Central Place Sydney project office
63 Kensington Street, Chippendale 2008

4 October 2022

Re: Toga State Significant Development SSD 33258337

I write representing Dexus CPA Pty Ltd (Dexus) and Henry Deane Building Nominees Pty Ltd & Gateway Building Nominees Pty Ltd (Frasers Property Australia), known as 'The Consortium', to provide this letter of in-principle support in response to the Toga Central State Significant Development 33258337 (SSD 33258337).

# Landscape Masterplan Ground Level

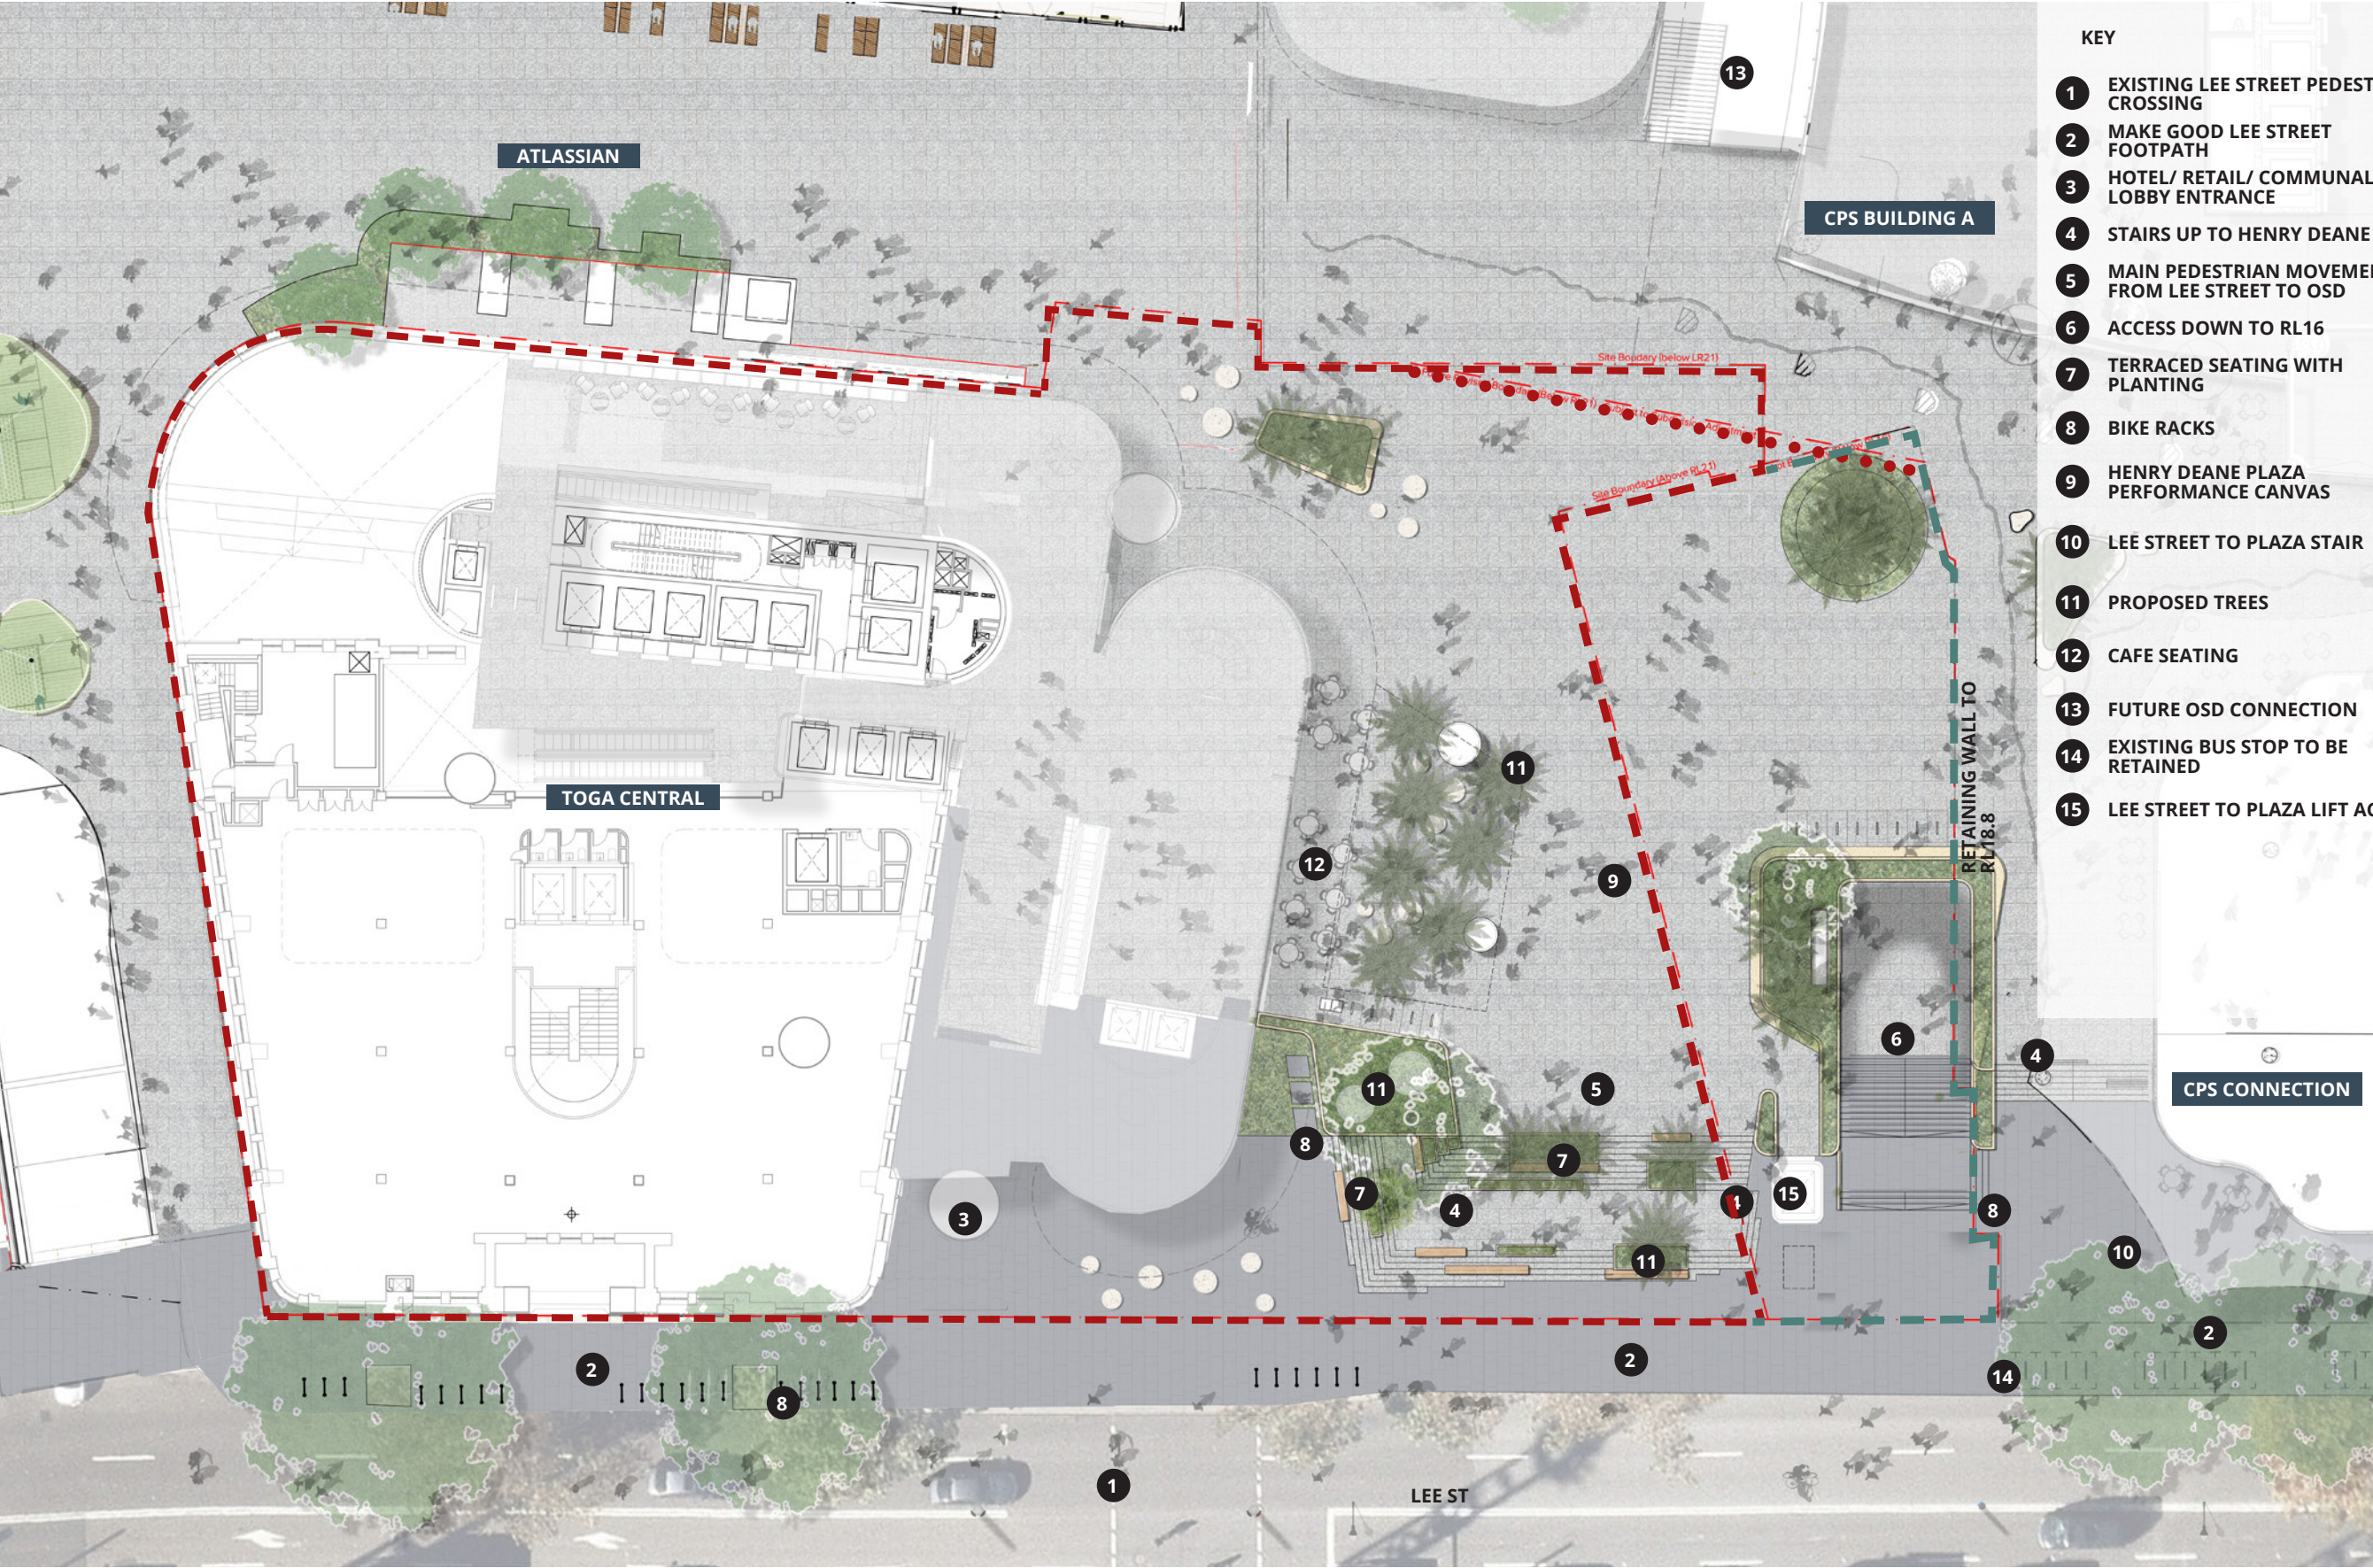
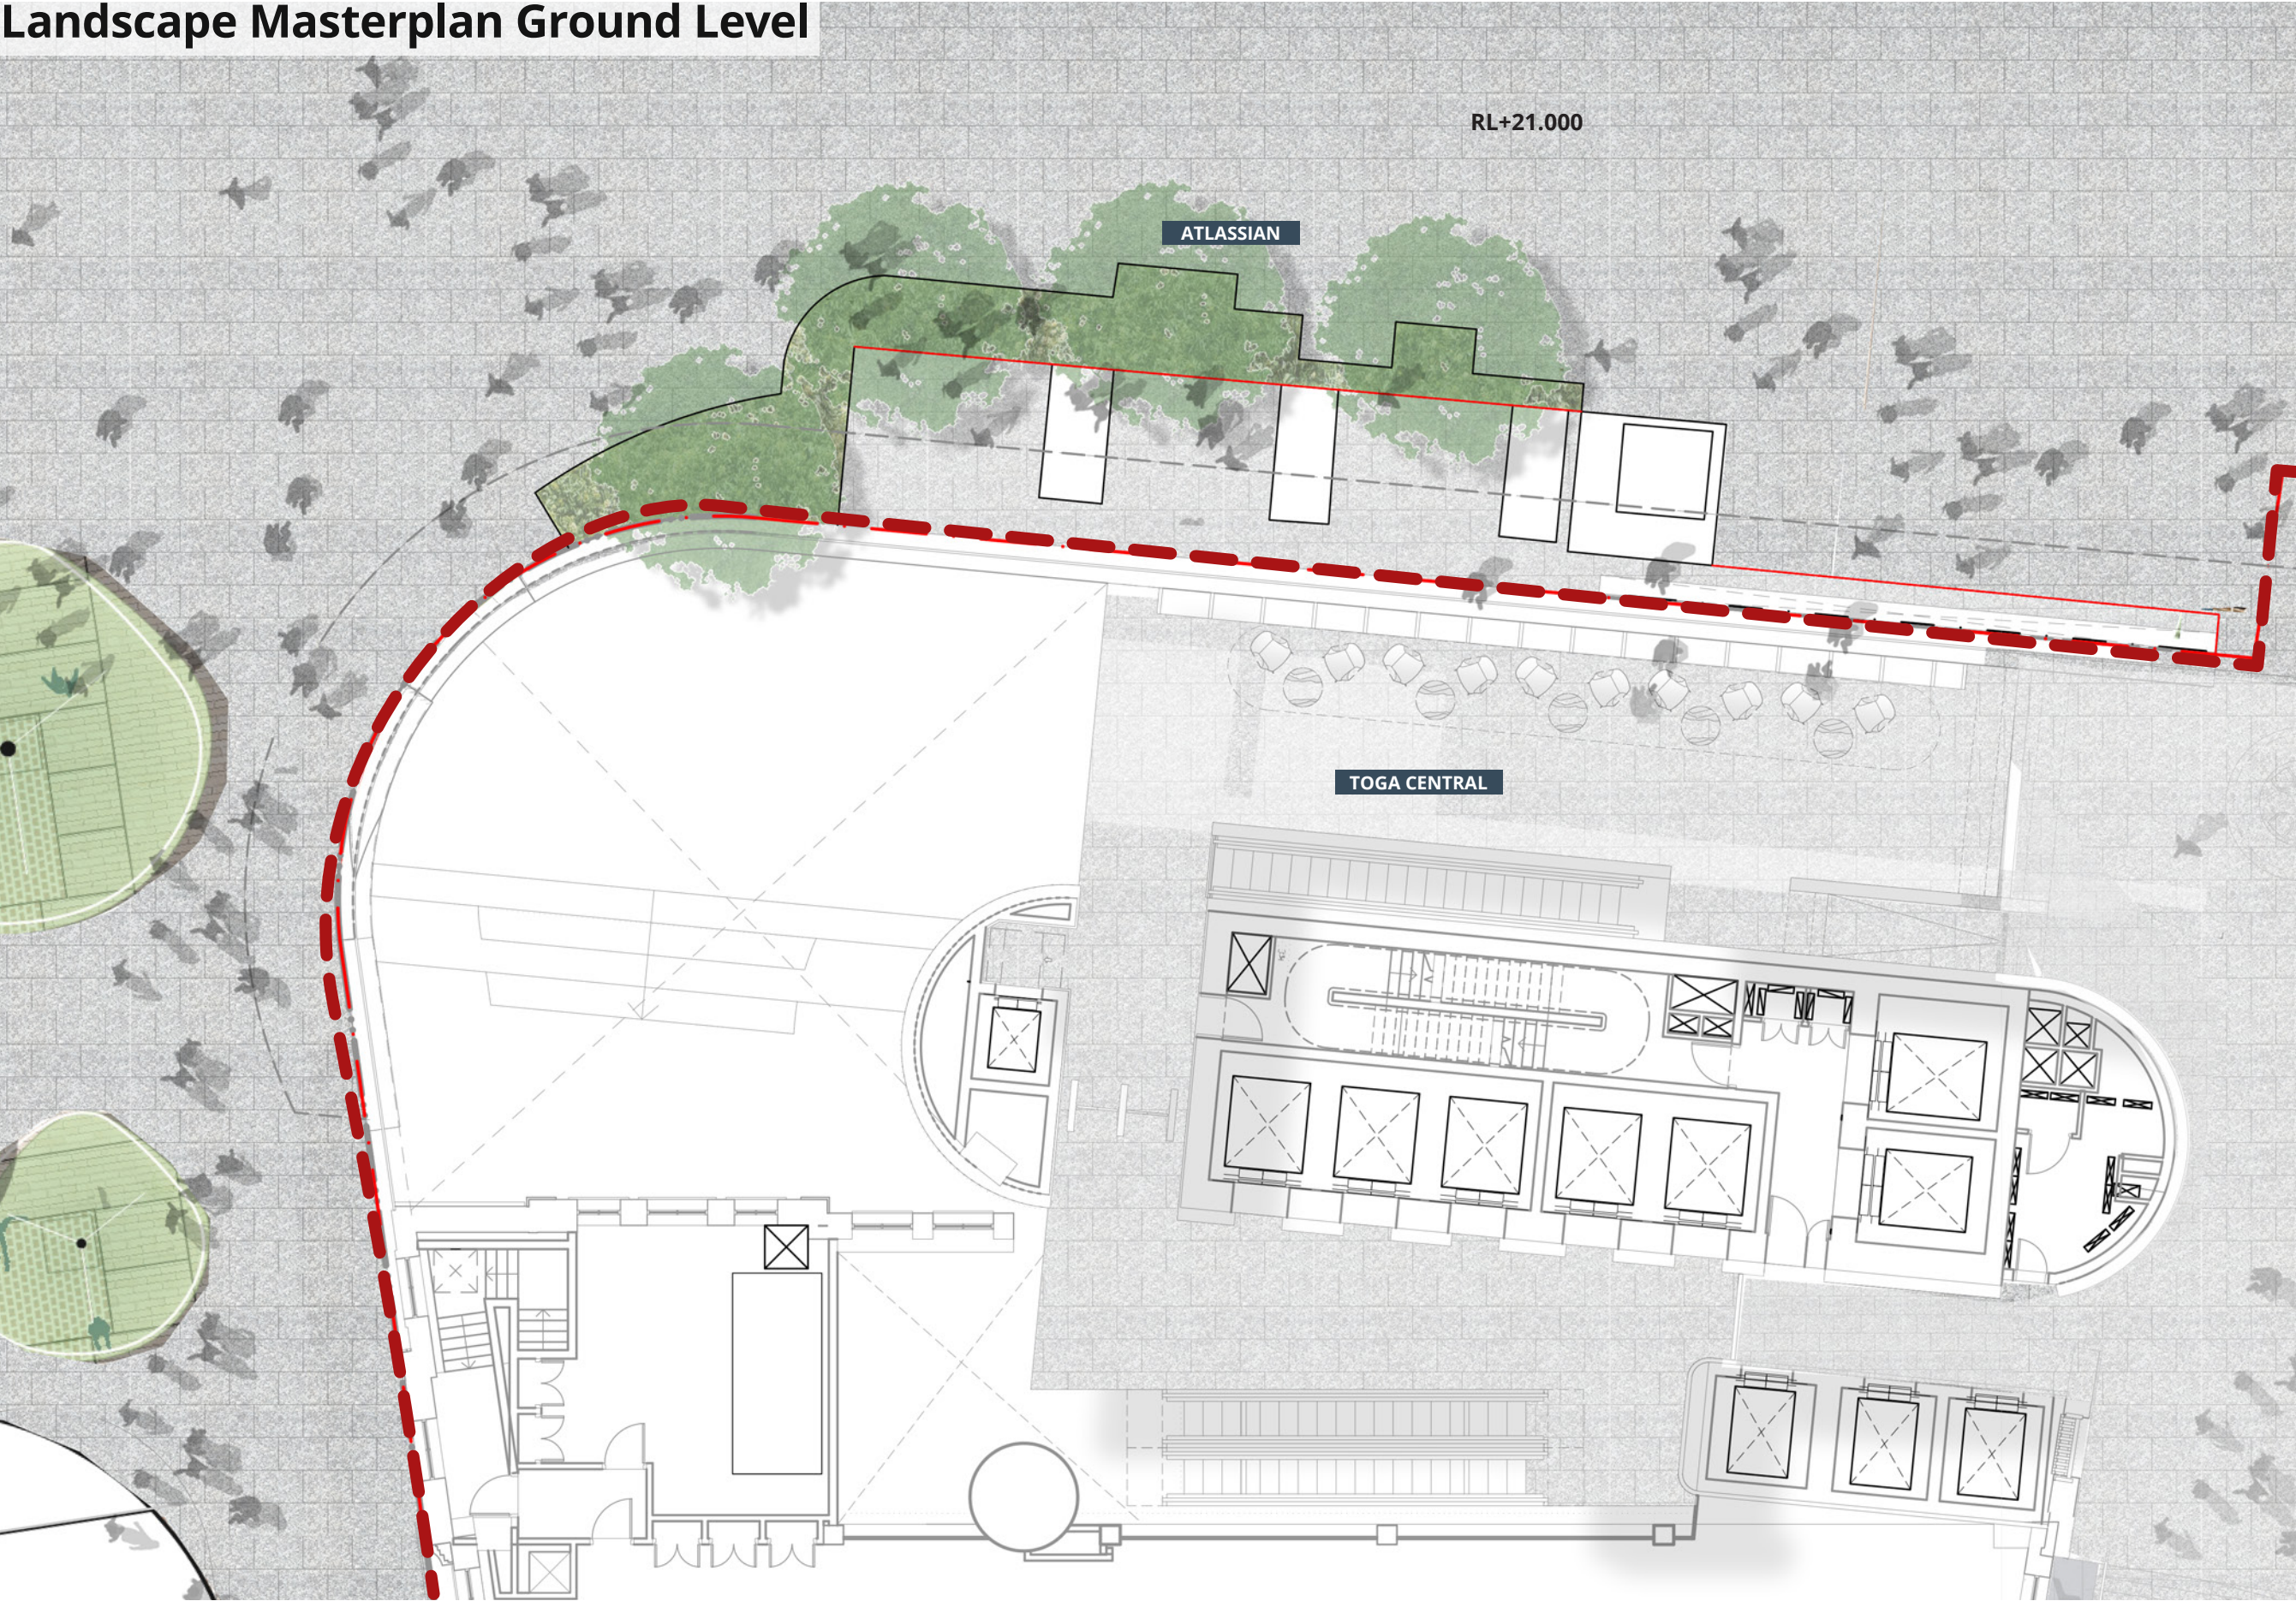
The Landscape and Public Domain Report ("Public Domain Report") prepared by Arcadia has made assumptions in regard to the public realm in areas outside of the Toga lot boundary, particularly as it relates to Upper Ground level. The DPE should be made aware that whilst this design is located on the Consortium's land, it is not supported by the Consortium. However, the Consortium is working closely with Toga and the City of Sydney Council to agree the best urban outcome for the plaza and public domain areas across the various landholdings and has confidence that a successful outcome can be reached.

We acknowledge that the best outcome is not defined by lot boundaries, however, highlight that consideration must be given to the volumes of pedestrian movements entering and exiting Central Station which is one of the busiest railway stations in Australia. Furthermore, the staging of the three Western Gateway Sub-precinct developments needs to be taken into account, to ensure adequate pedestrian access is provided as each development is completed.
